Letter No.C4/26562/2002

Sub: CMDA - Area Plans Unit - Planning  
permission for the Regularisation of  
unauthorized construction of Shrimathi  
Devkunver Namalal Bhakt Vaishnav College  
for Women, Chrompet at S.No.425/3,4,  
430/6 and 431/3 of Zamin Pallavaram  
village

Letter No. C **4/26562/2002**

Sub: CMDA - Planning permission - Proposed - Regularisation  
of unauthorised construction of Shrimathi Devkunvar  
Namalal Bhatt Vaishnav College for women Chrompet,  
Chennai-44 at S.No.425/3,4, 430/6 and 431/3 of  
Zamin Pallavararam Village Development Charges  
and other charges to be remitted - Regarding.

SITE PLAN
 SCALE: 1" = 320', 1" = 400'

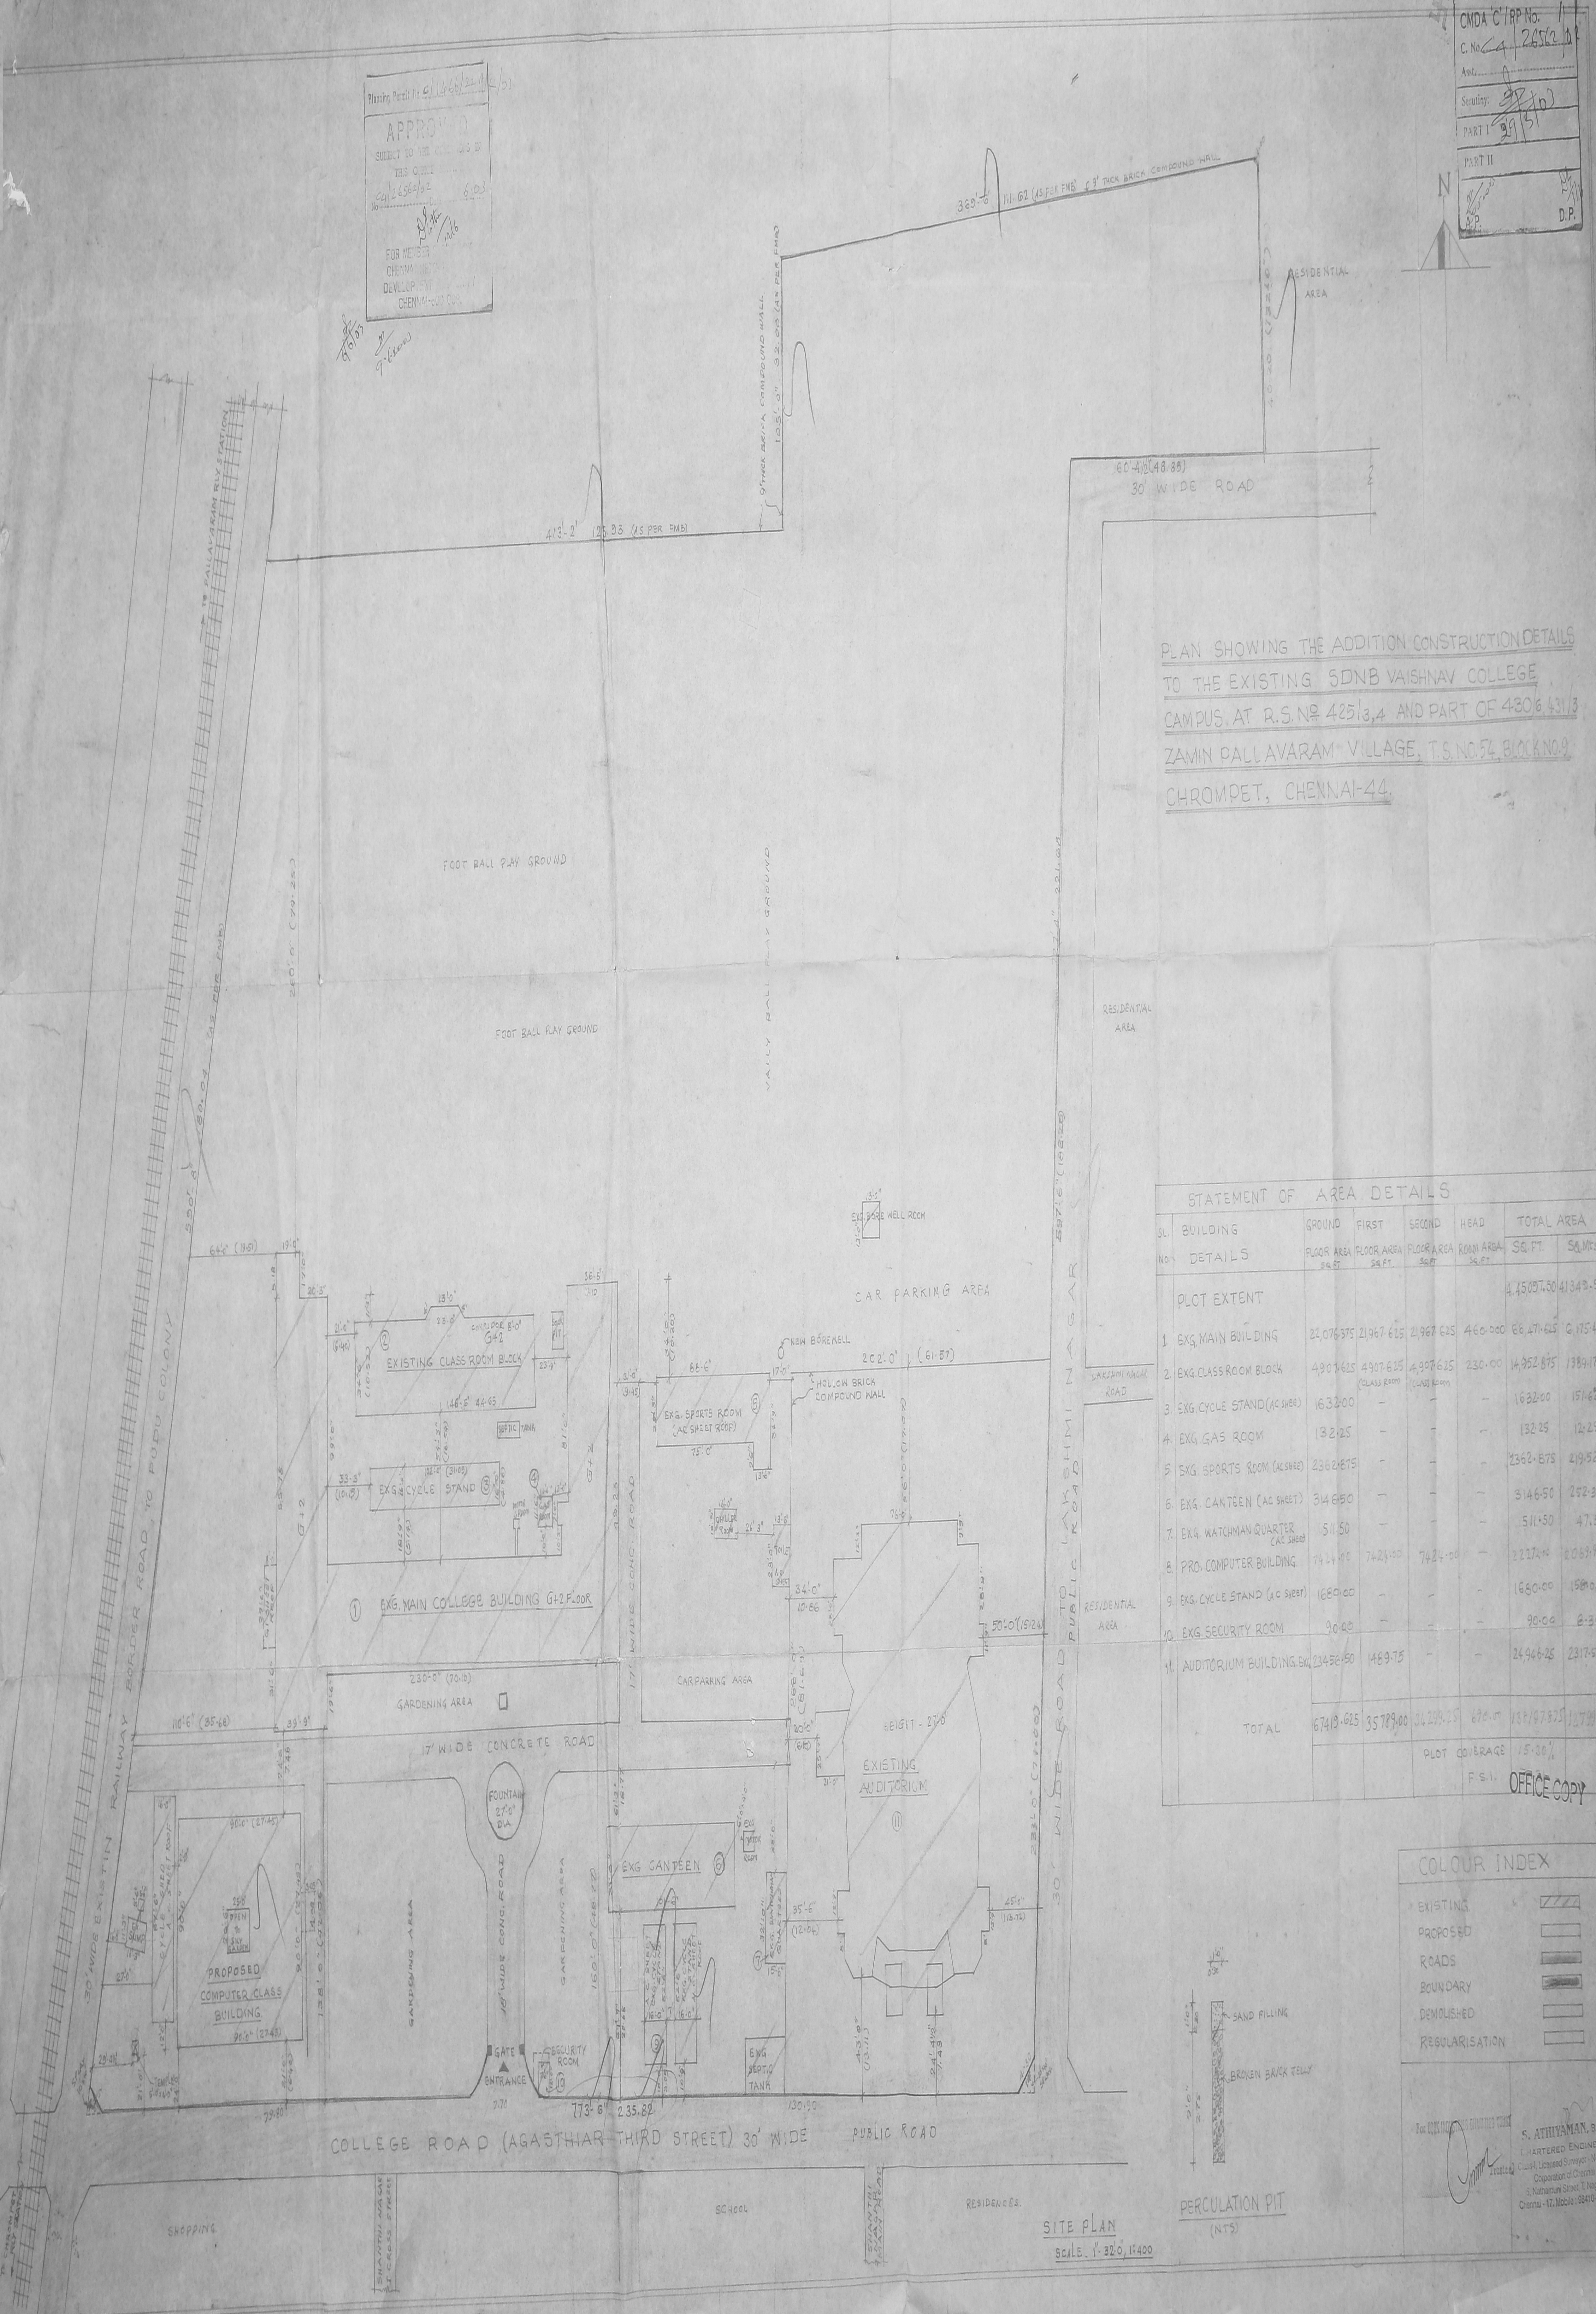
- a) Rain water conservation measures notified by CMDA should be adhered to strictly.
- b) **Boundary measurement do not tally with Field Measurement Book sketch (Souther side).**
- c) **Sanctioned demolition plan (for A/C Sheet roof) cycle shed not furnished.**
